Statement of Case

- 0.1 An Appeal is being filed for determination by the Planning Inspectorate of Application Ref 23469/APP/2022/144 submitted to the LB of Hillingdon. The application was for *“Erection of new 3 bedroom bungalow with dormers and rooflights serving accommodation in the roof on land to the front of existing dwelling.”* The location is on land to the front of 170 Harefield Road, Uxbridge, and is neither Listed nor in a Conservation Area. The property is located on the South-eastern side of Harefield Road, a road connecting residential districts to the North of Uxbridge Town Centre.

PROPOSED GROUND
FLOOR PLAN

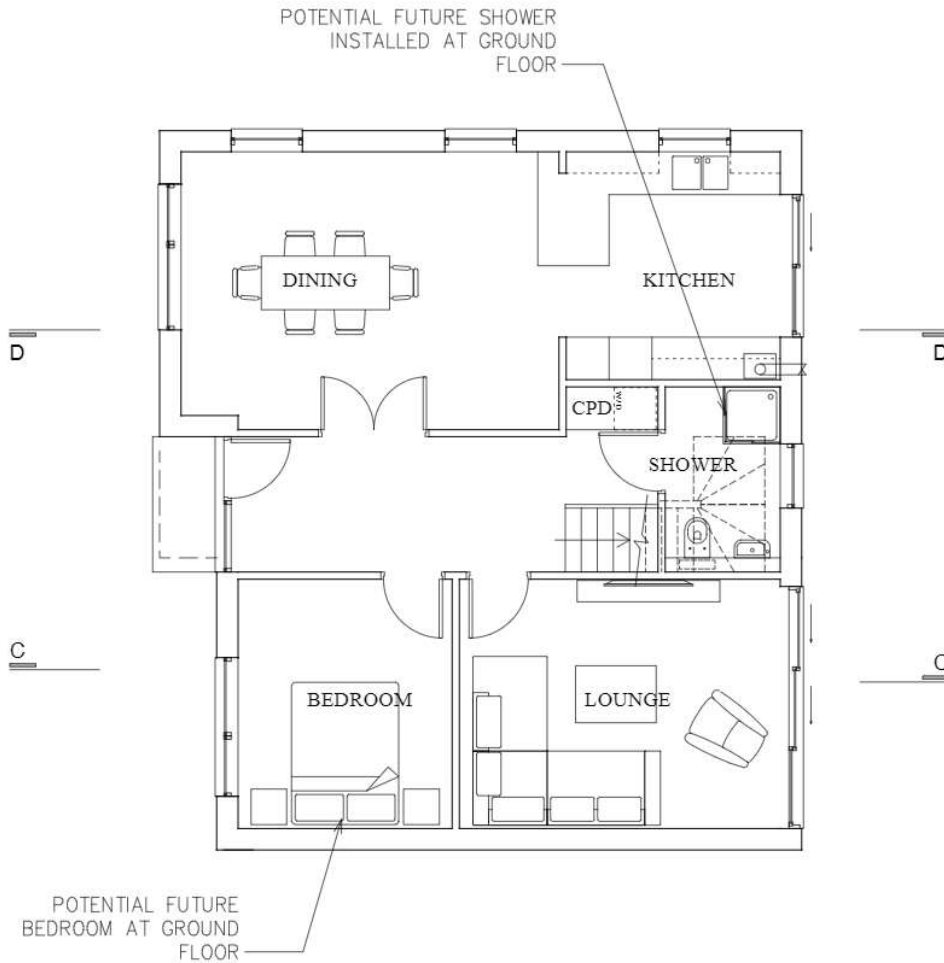
- 0.6 A third reason for refusal has been given as: *“The design of the building fails to meet the requirements set out in Policy D7 of the London Plan (i.e. creation of an M4(2) compliant dwelling) and our Access officer has recommended refusal of the scheme.”* Self-evidently the Appellant has not seen the detail of the recommendation.

- 4.3 The dwelling as designed would readily comply with all these provisions and it remains unclear to the Appellant which details of M4(2) compliance have resulted in the Access officer's recommendation for refusal. This is particularly confusing since the arrangements are not dissimilar to those for the consented dwelling to the rear of No. 170 which were recently approved under the same principles. While that dwelling included a bedroom and shower room at ground floor level, these are the provisions of the code which can be subject to adaptation.

- 4.4 The Appellant has prepared a revised internal layout for the proposed dwelling which demonstrate how it can readily be adapted to provide for M4(2) compliance. This illustrates how this reason for refusal could readily have been resolved through discussion with the applicant during assessment of the application.

Revised internal layout demonstrating compliance with M4(2)
